Application Reference: 2025/0698

Site Address: 128 Dodworth Road, Barnsley, S70 6HL

Introduction: Installation of front dormer

PROPOSED FLOOR PLANS

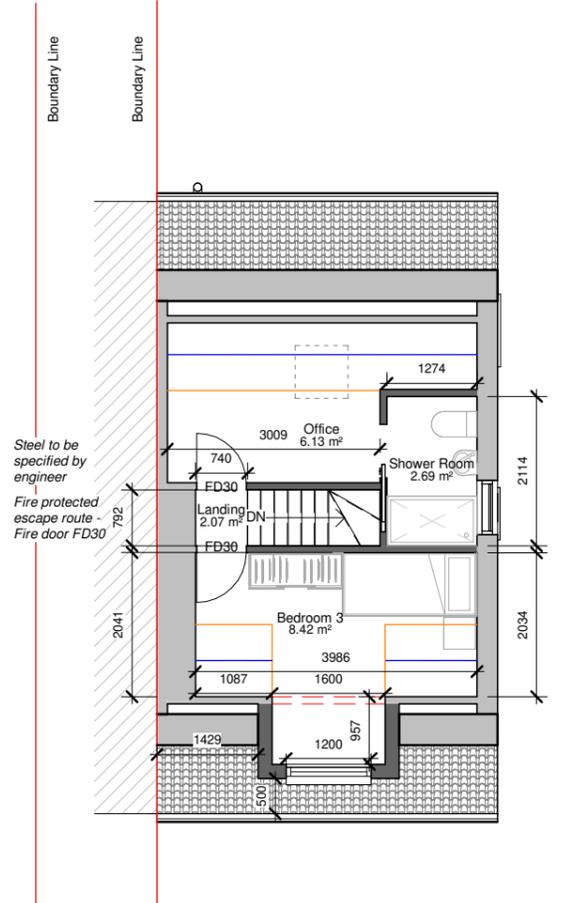
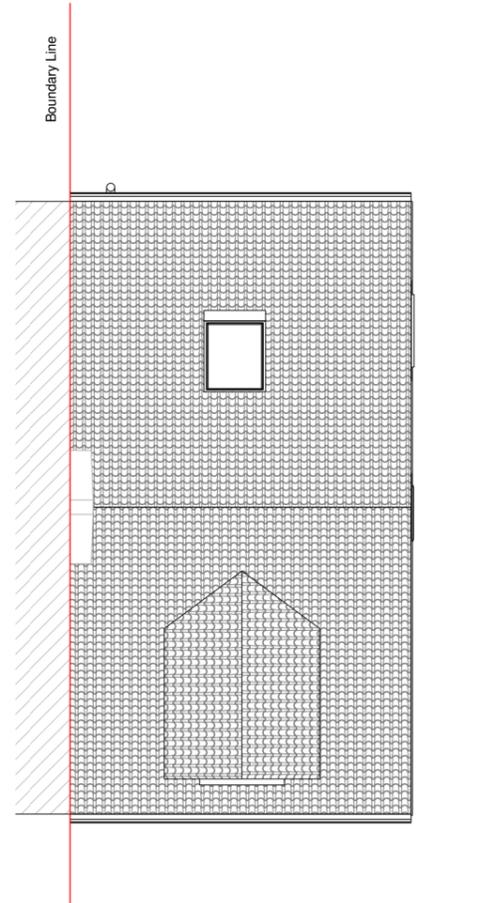
The proposed dormer window has been detailed to an acceptable size and scale when assessed against the House Extensions SPD. The dormer is set below the existing roof ridge, a minimum of 0.5 metres has been retained between the front of the dormer and the existing roof eaves and a greater distance than 0.5 metres has been detailed between the cheeks of the dormer and adjacent properties. A gable roof form has been detailed. Although gable roofed dormer are not specifically commonplace within the street scene, the use of differing roof designs with gable features which provide a similar impact to the proposal are commonplace. The dormer would therefore not look out of place with the character of the street scene. The dormer has been placed centrally to the dwelling and lines up vertically with the existing ground and first floor front elevation glazing.

Front elevation

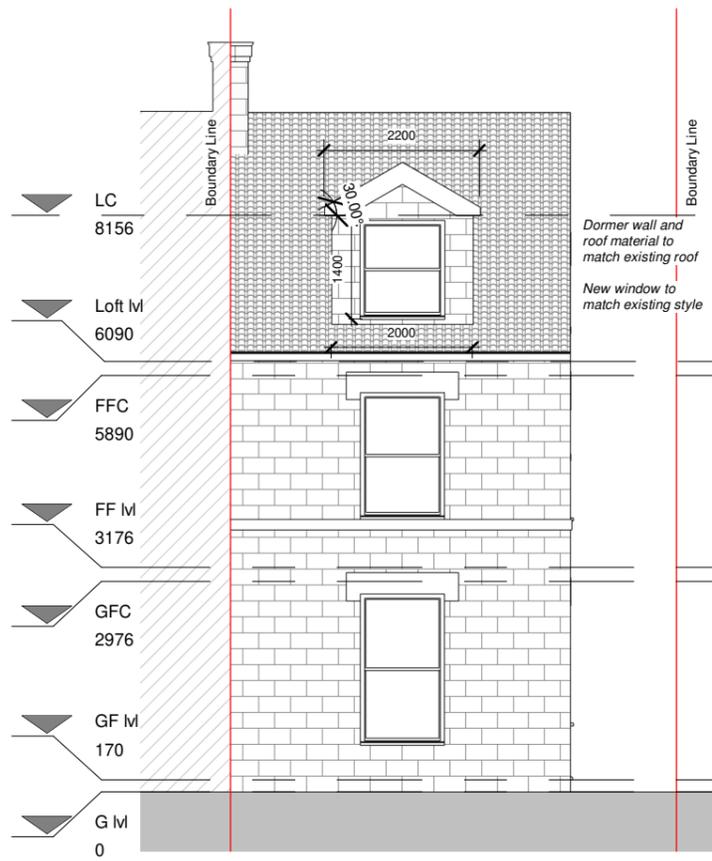
Although materials to match the existing roof have been proposed, roof tile cheeks and roof tiled front elevation would not be beneficial to the character of the dwelling and street scene as the existing roof material is modern concrete interlocking tiles rather than plain tiles or slates. Other gable features within the street scene provide stone frontages. Furthermore, although the proposed elevations label the dormer cheeks and front elevation as 'matching existing roof', the use of stone which has been detailed on the elevations provides a more in keeping and appropriate material choice. Given specifically, front elevation dormers are not commonplace in the street scene but gable features are, the use of stone to match the front and side elevation walls is preferred. As such the cheeks and front elevation of the proposed dormer will be conditioned to be constructed from stone or matching materials to the front elevation walls of the dwelling. It would be appropriate for the proposed roof materials to the dormer to be matching the existing roof.
